From: Joanne Lewis <Joanne.Lewis@arun.gov.uk>
Sent: 01 December 2020 17:25
To: Planning.Responses <Planning.Responses@arun.gov.uk>
Subject: RE: Planning Consultation on: Y/126/20/DOC

6 - Construction & Environmental Management Plan

Site Address: Land East of North End Road and West of Church Lane Nursery Yapton BN18 0GA

Description of Works: Approval if details reserved by condition imposed under ref Y/18/20/PL relating to Condition Nos 6 - Construction & Environmental Management Plan, 9 - mitigation method statement re hedgerows, 10 - wildlife enhancement, 11 - landscaping, 12 - materials & finishes, 13 - screen walls & fences, 14 - Part M of Building Regs 2010, 16 - cycle parking, 18 - energy efficiency, 19 - electric vehicle charging and 20 - external lighting

PROPOSED CONSTRUCTION PLAN
(1:200)

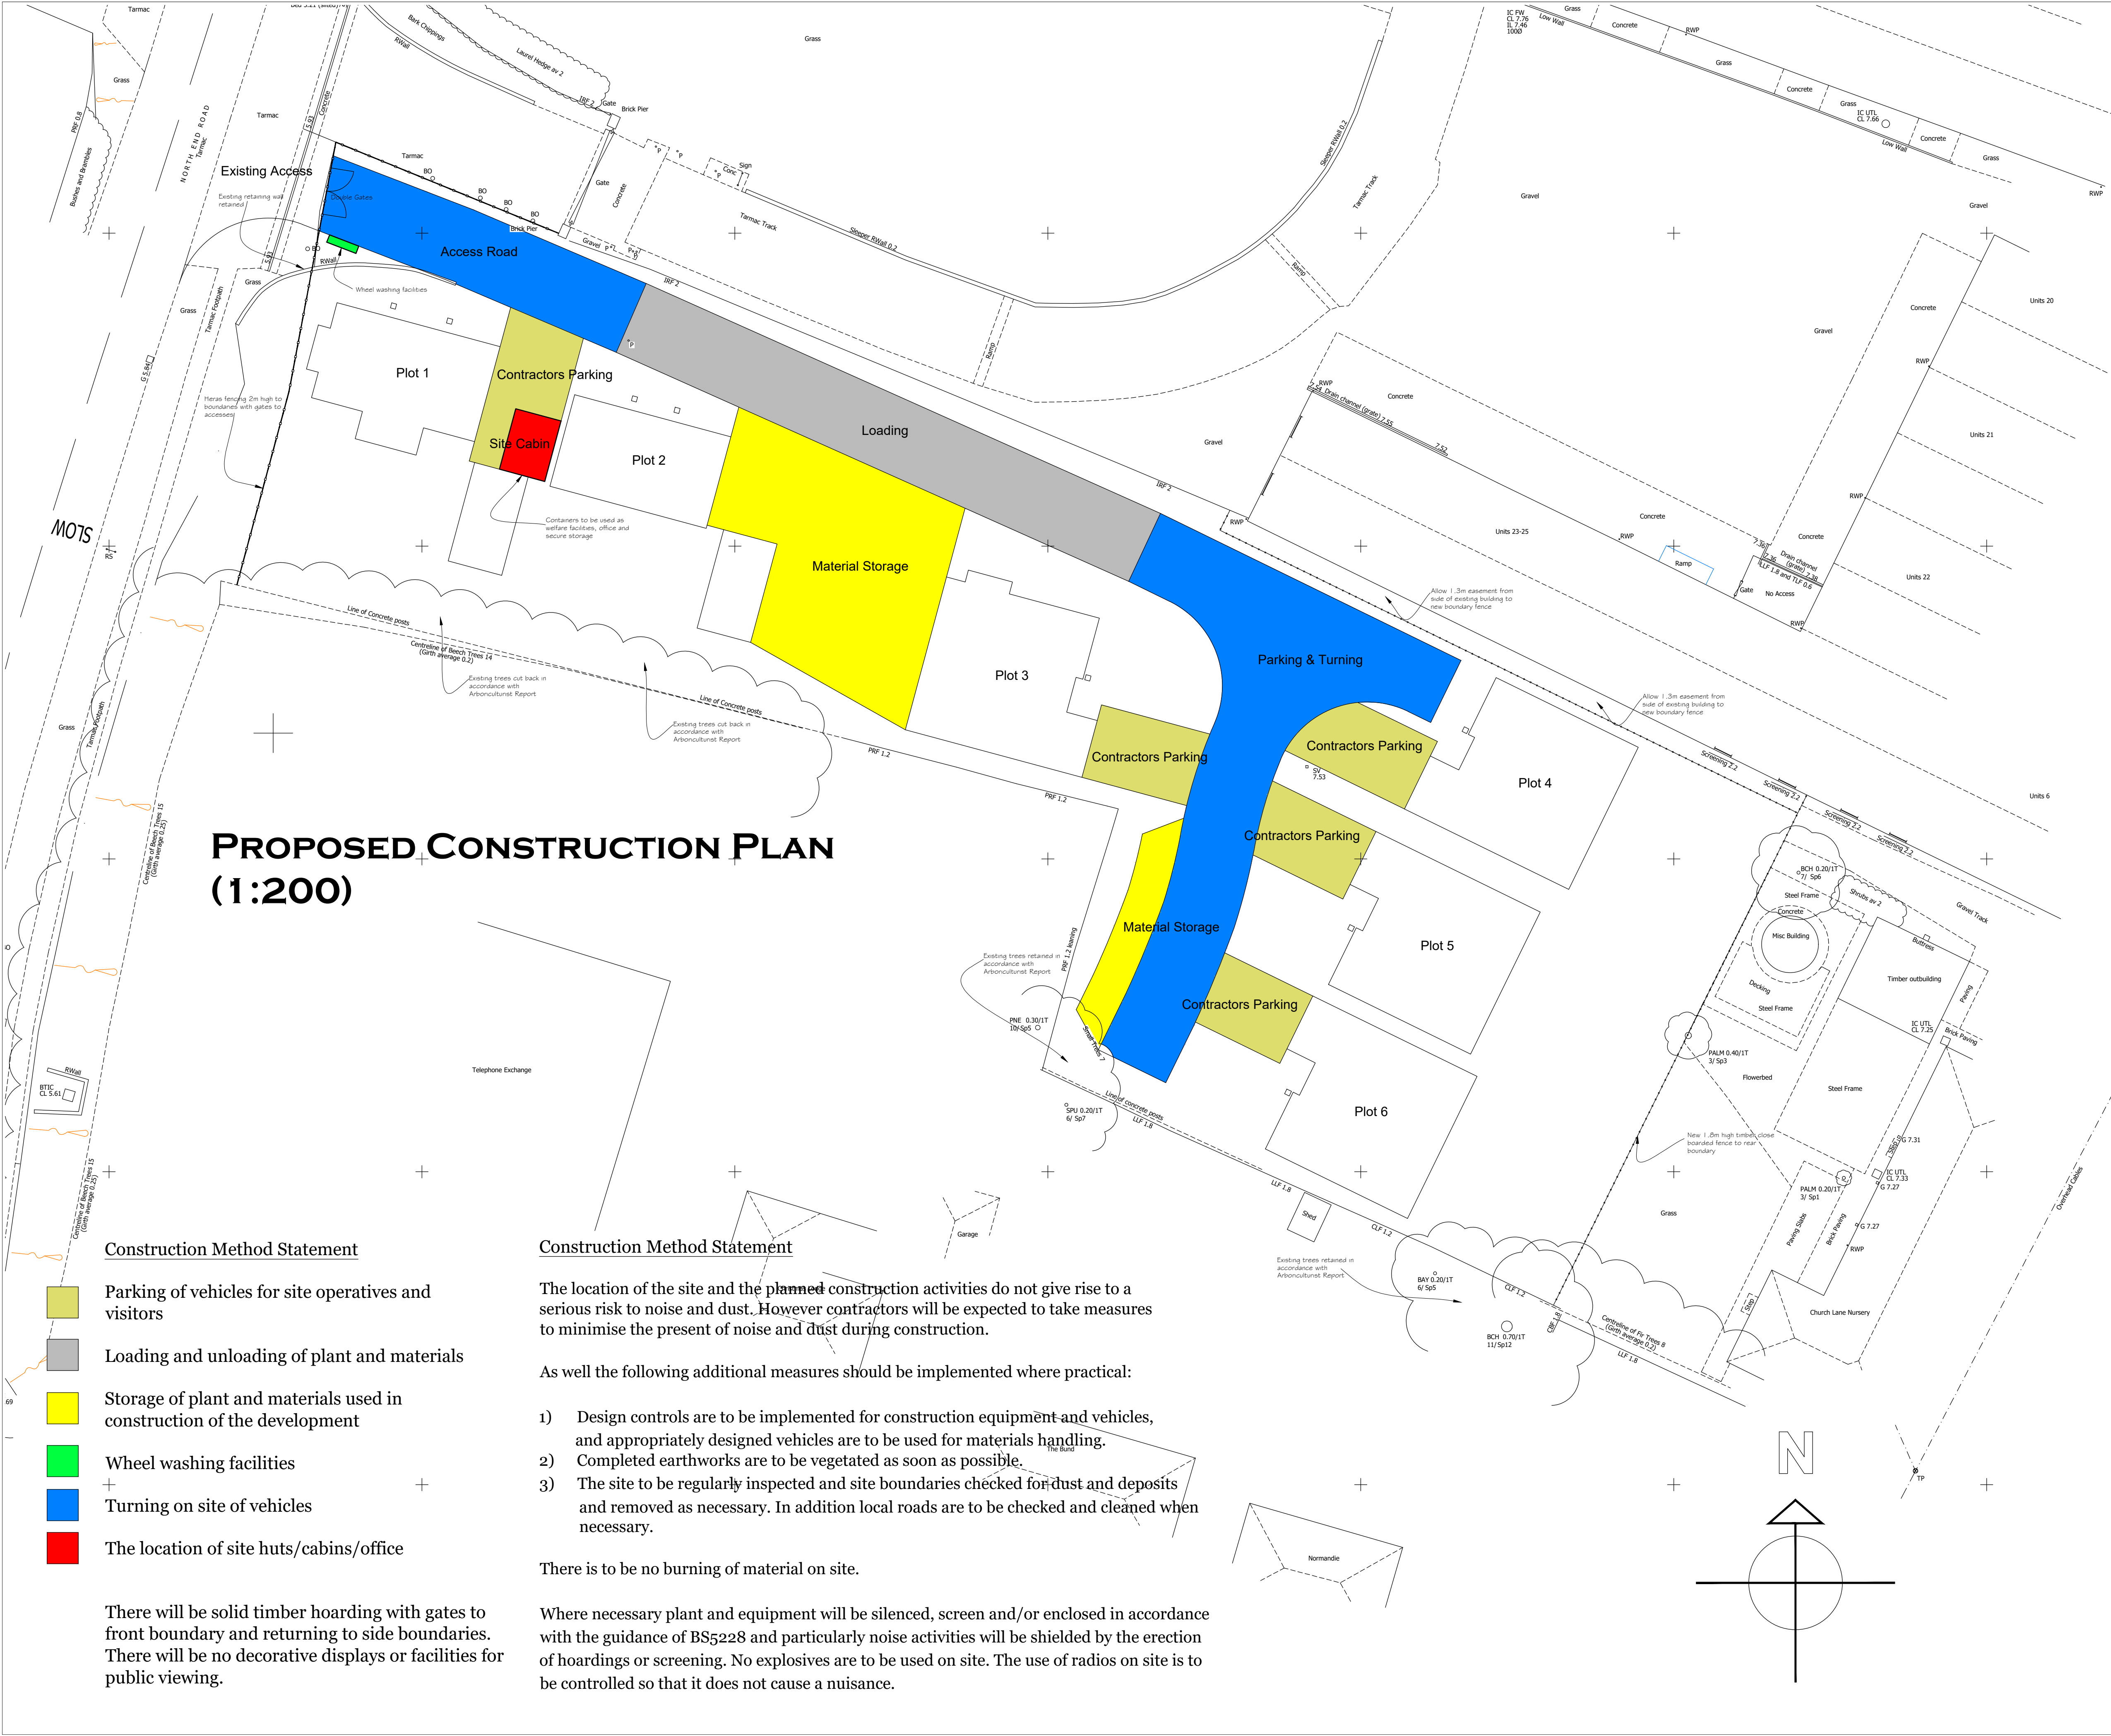
- An indicative programme for the works has not been provided.
- Annotations on the proposed construction plan shows 2m high heras fencing to the front of the site but the construction method statement at the bottom states that there will be solid timber hoarding with gates to the front boundary and returning to side boundaries. The document CEMP by Vivio also makes separate references to solid fencing and sheeted heras fencing. Please be clear about which is to be provided and where. Heras fencing plays no role in protecting existing neighbours from noise or dust so this should not be used on boundaries that adjoin existing residential properties.
